Application for Removal or Variation of a Condition following Grant of Planning Permission or Listed Building Consent

Number	5
Suffix	
Property Name	
Address Line 1	Woodsome Drive
Address Line 2	Fenay Bridge
Address Line 3	Kirklees
Town/city	Huddersfield
Postcode	HD8 0JR

ERECTION OF SINGLE STOREY REAR, TWO STOREY SIDE AND TWO STOREY
FRONT EXTENSIONS

2024/62/91084/W

Plans - As Proposed

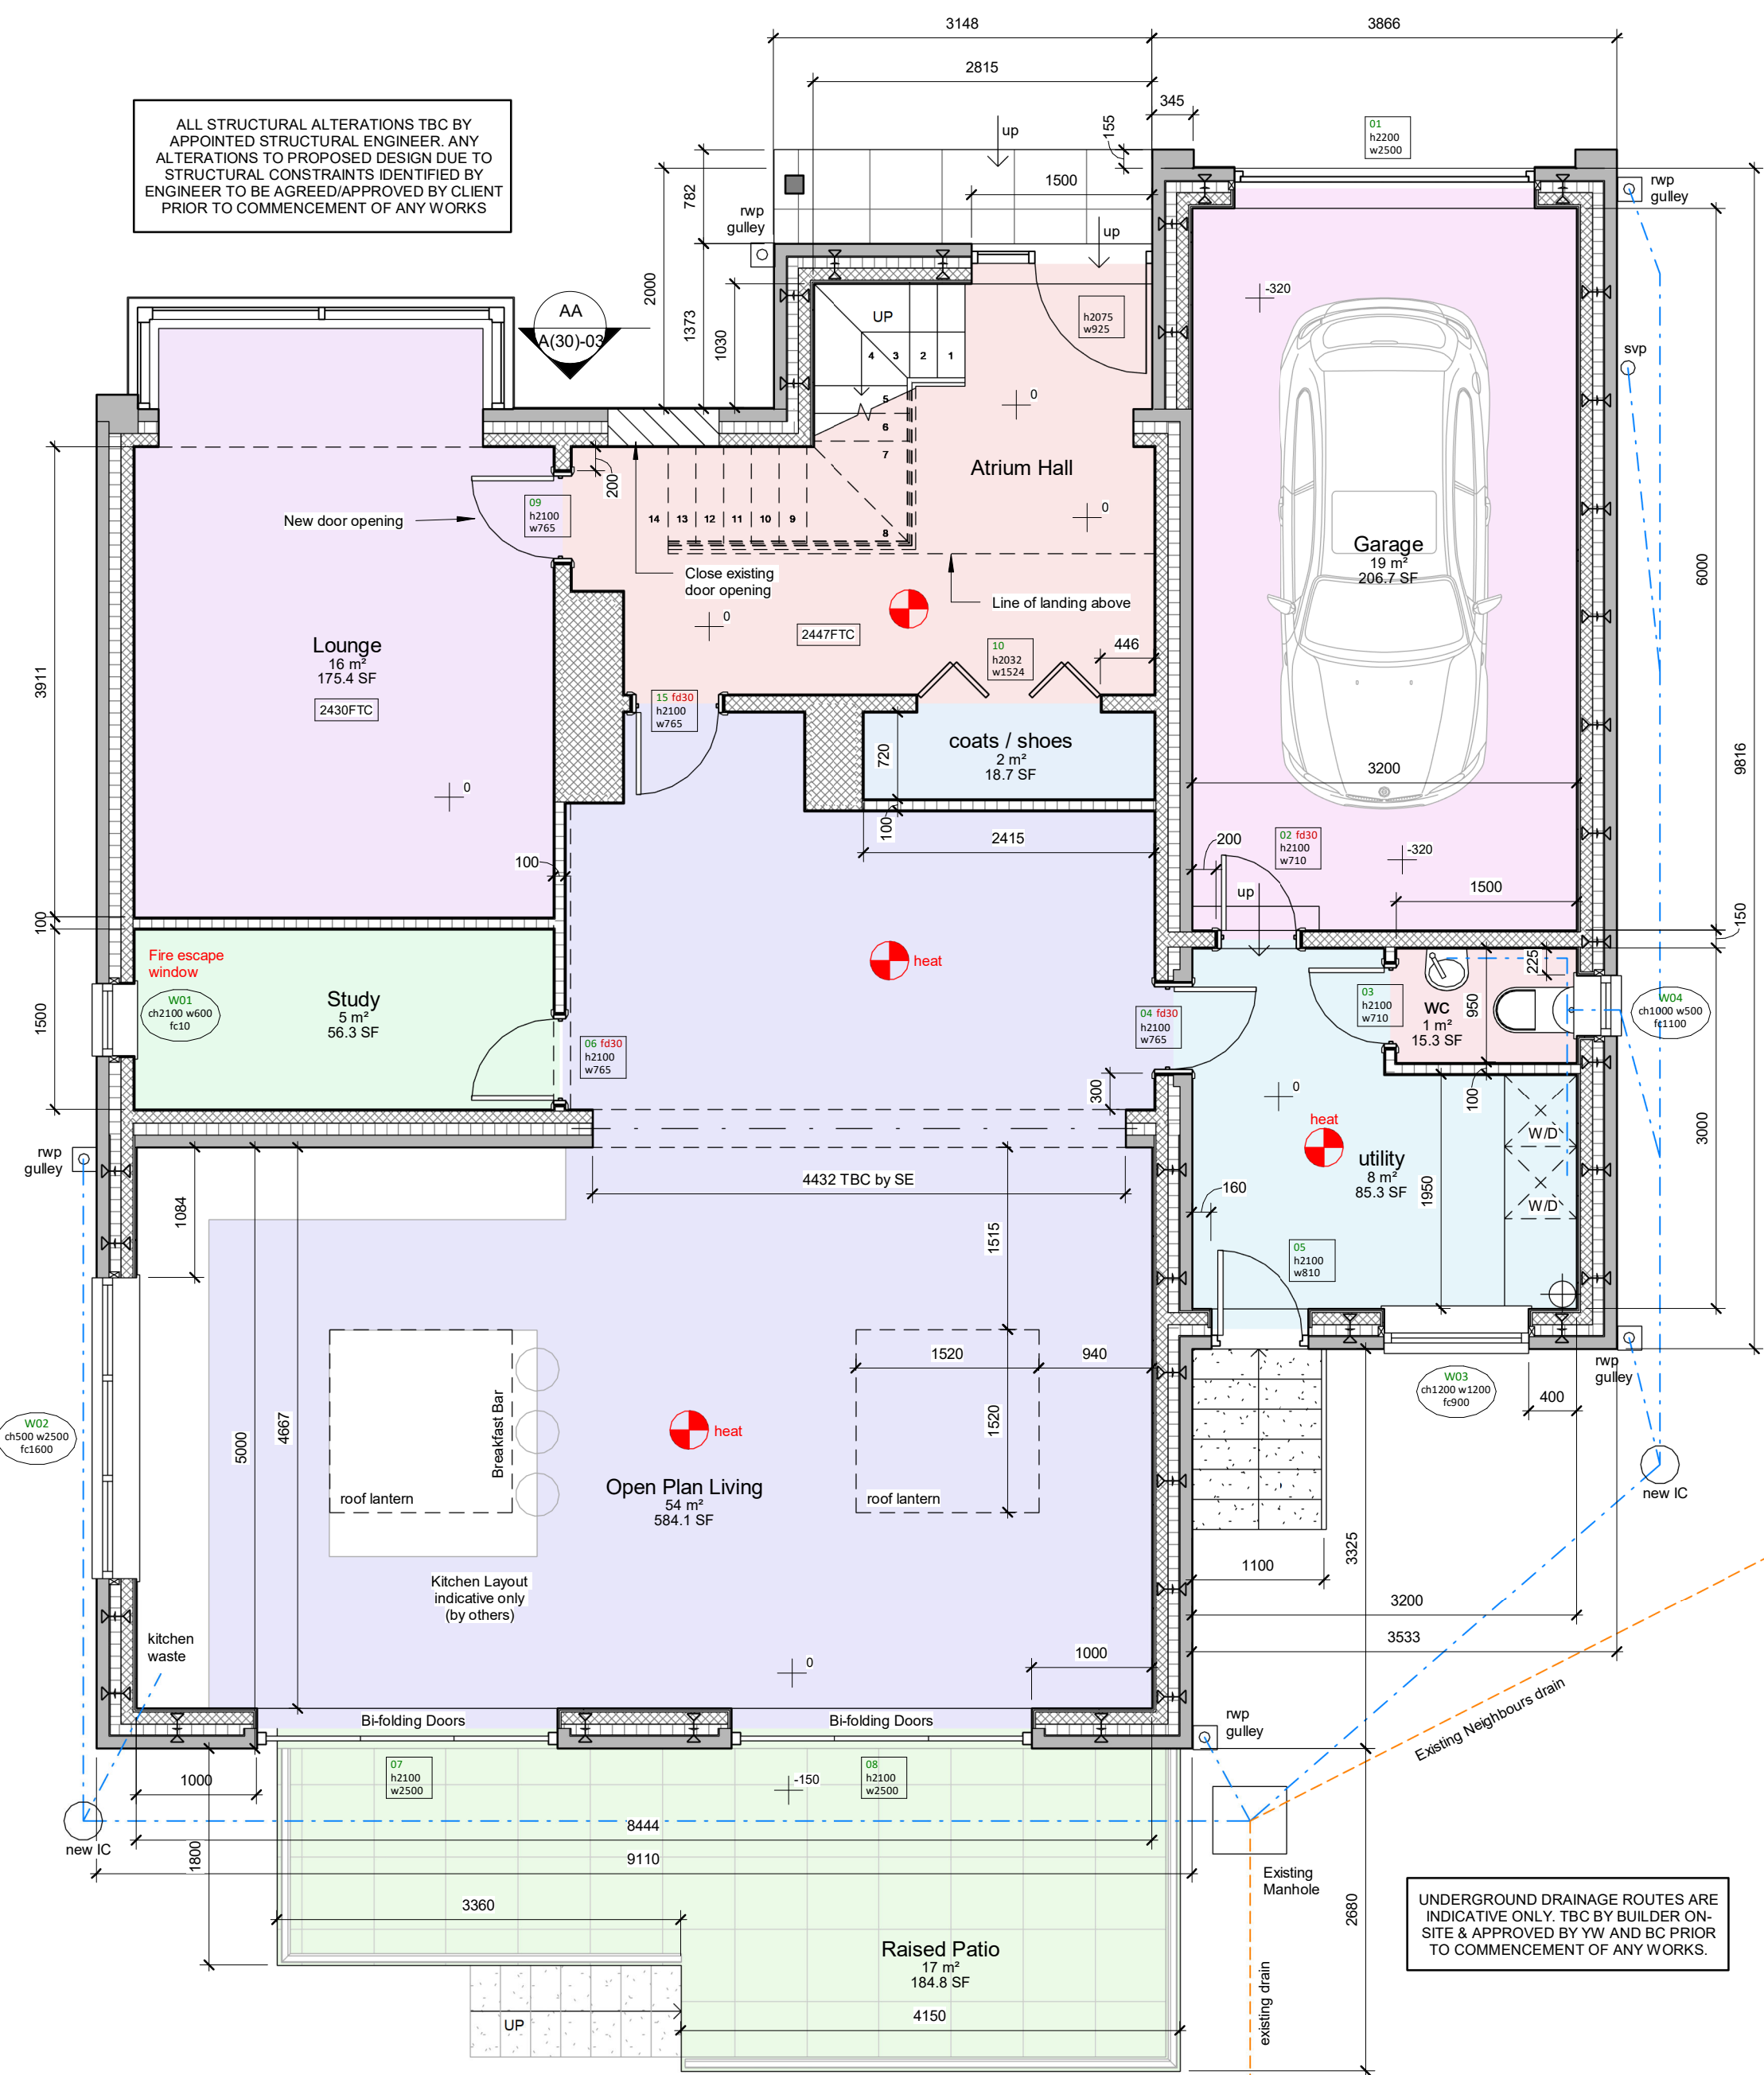
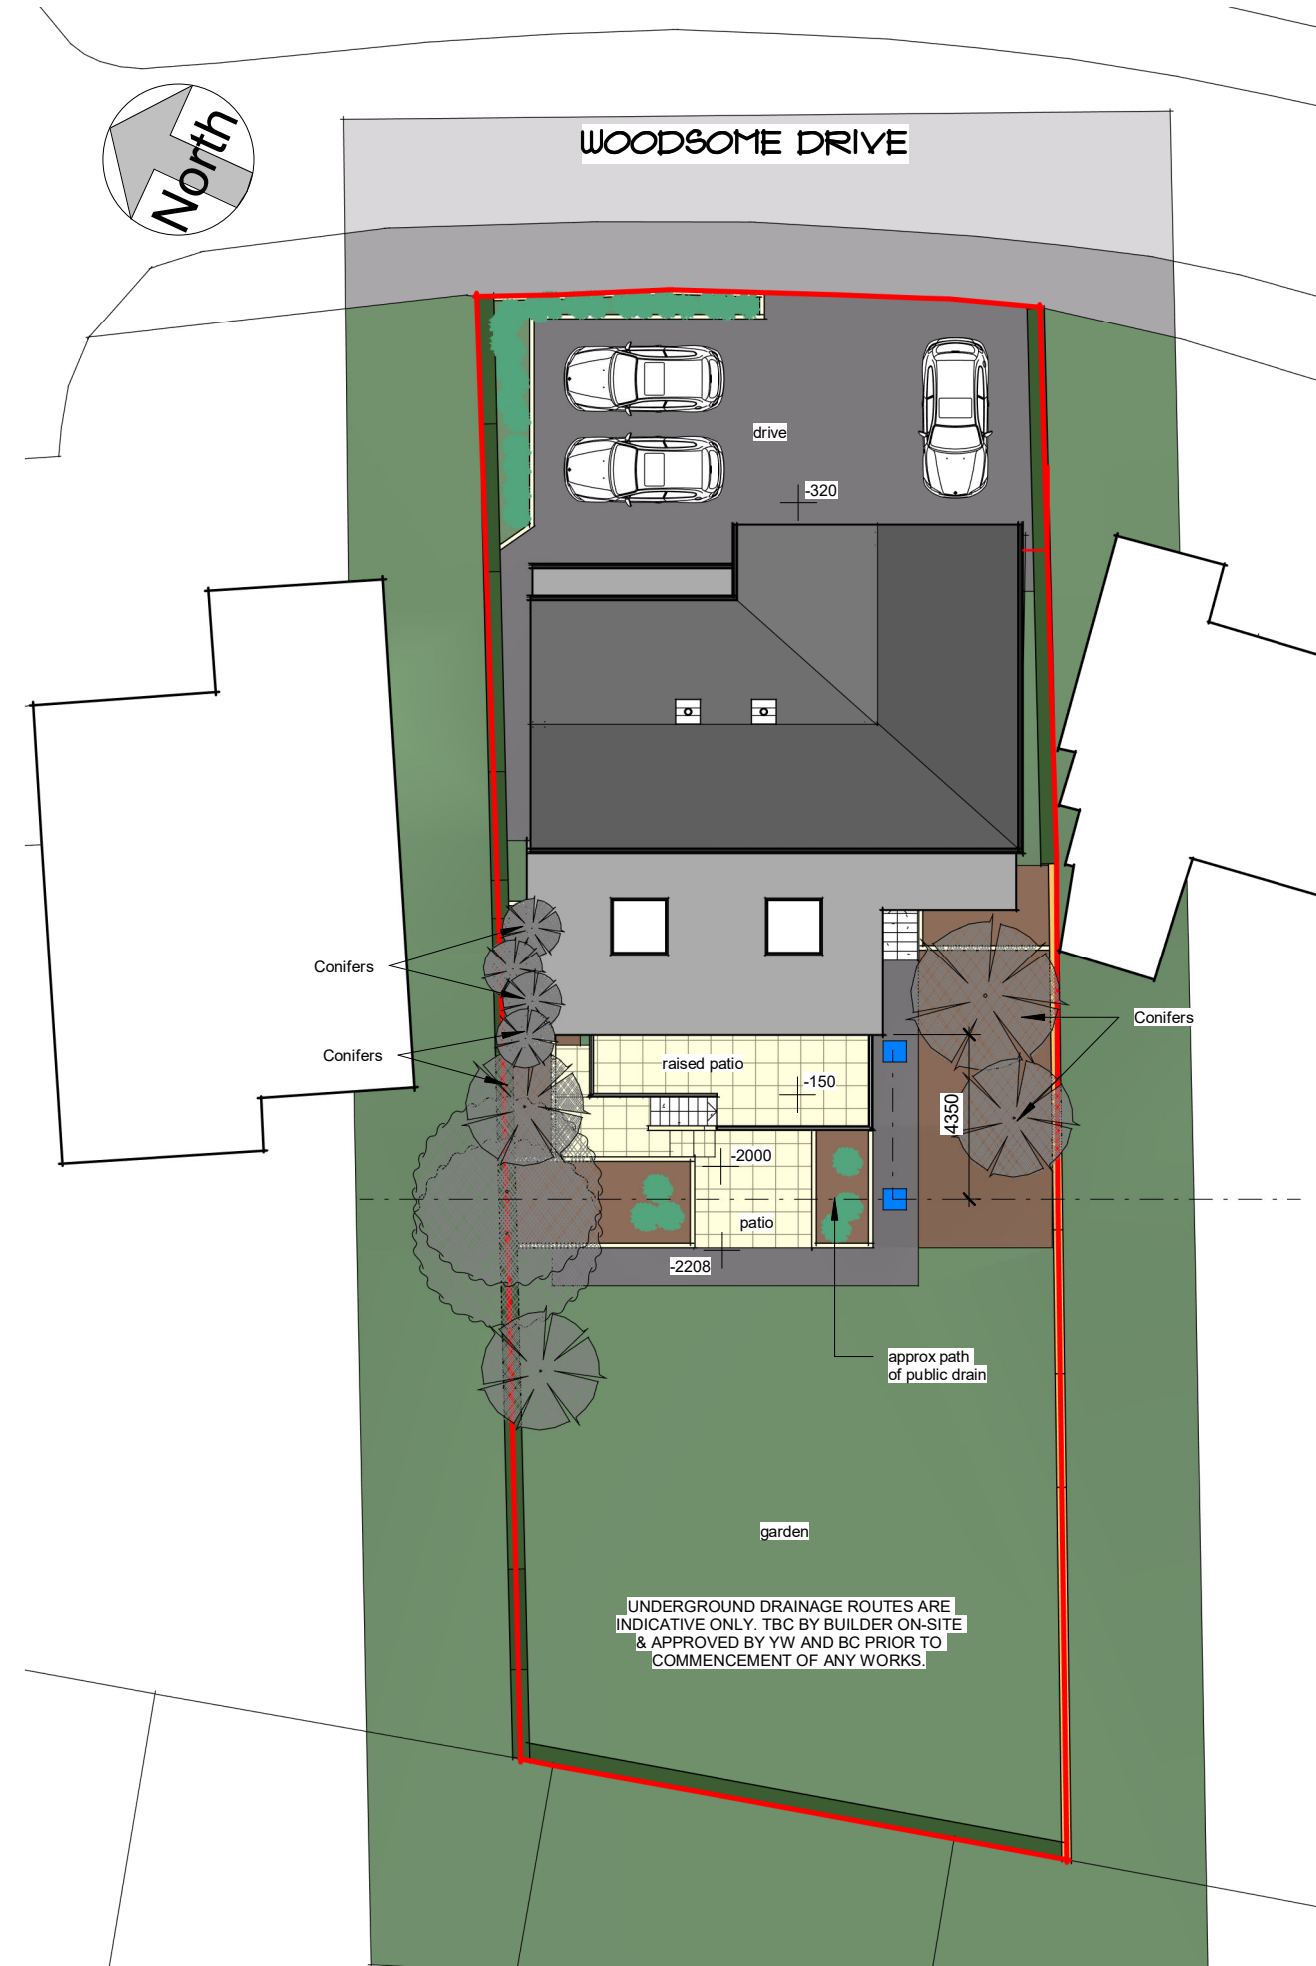
rear extension increased in width and door positions amended
first floor layout amended
front first floor window amended
rear first floor windows added

varied to accept minor changes as listed above and shown on updated submitted drawings
